Recommendation Report for Works to Tree(s) on trees subject to a Tree Preservation Order (TPO)

REF NO: AW/321/18/T

LOCATION: 106 Barrack Lane
ALDWICK
PO21 4EA

PROPOSAL: Reduce by 1m to old cuts 2No. Oak tree and reduce by 2m to 1No. Maple tree.

106 Barrack Lane

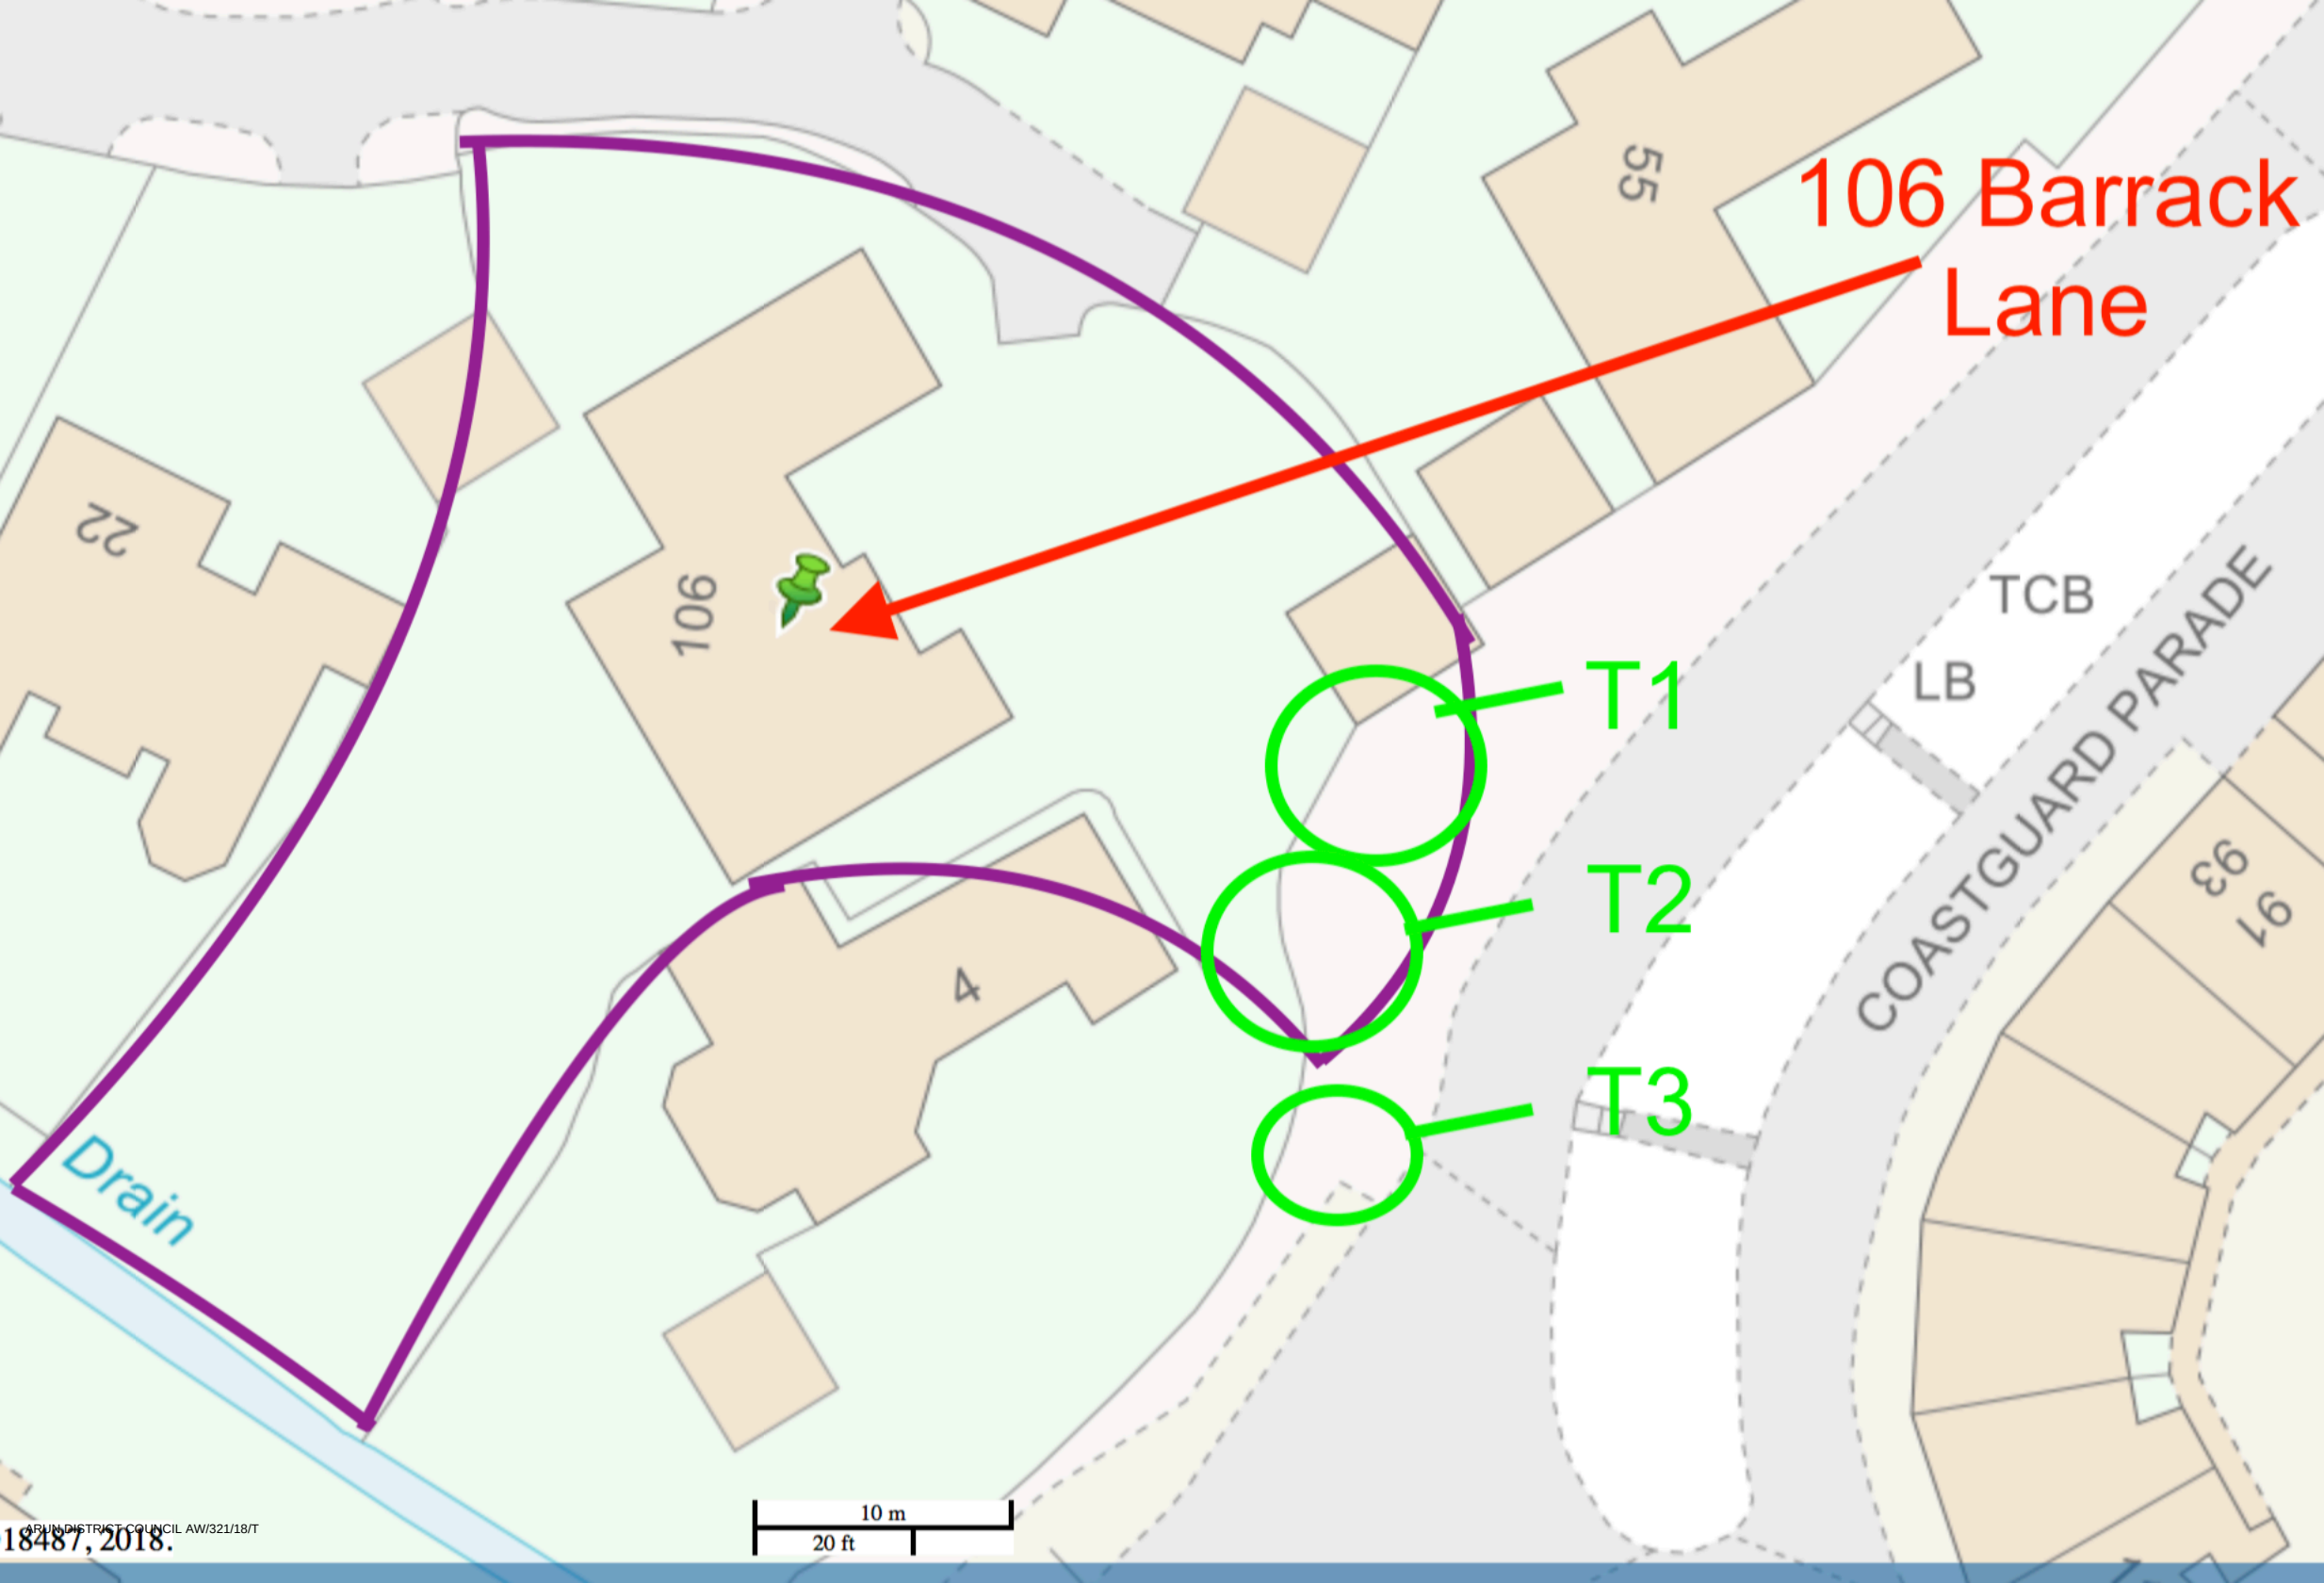
·T1 is a low quality specimen, having been suppressed by companion trees.

·T2 and T3 have been the subject of past crown modifications resulting in relatively small and compact limb/branch framework. This work was most recently undertaken late 2015/early 2016.

-T1 - Field maple is not the subject of any Order (TPO) nor does it reside within Conservation Area, therefore the consent of the local planning authority is not required before undertaking any work to this tree.

·T2 and T3 - Cyclical crown reduction work throughout the remaining life-span of these trees will be necessary to achieve a degree of structural integrity appropriate for their location.

·T2 and T3 - There is insufficient extension of new growth (1-1.5m) since the last major pruning operation (c2015/16); so that repeat crown reduction at this time (or within the next 2years) would be too early in the management cycle and likely have a negative effect on their long-term vitality.

·I recommend REFUSAL for this application.
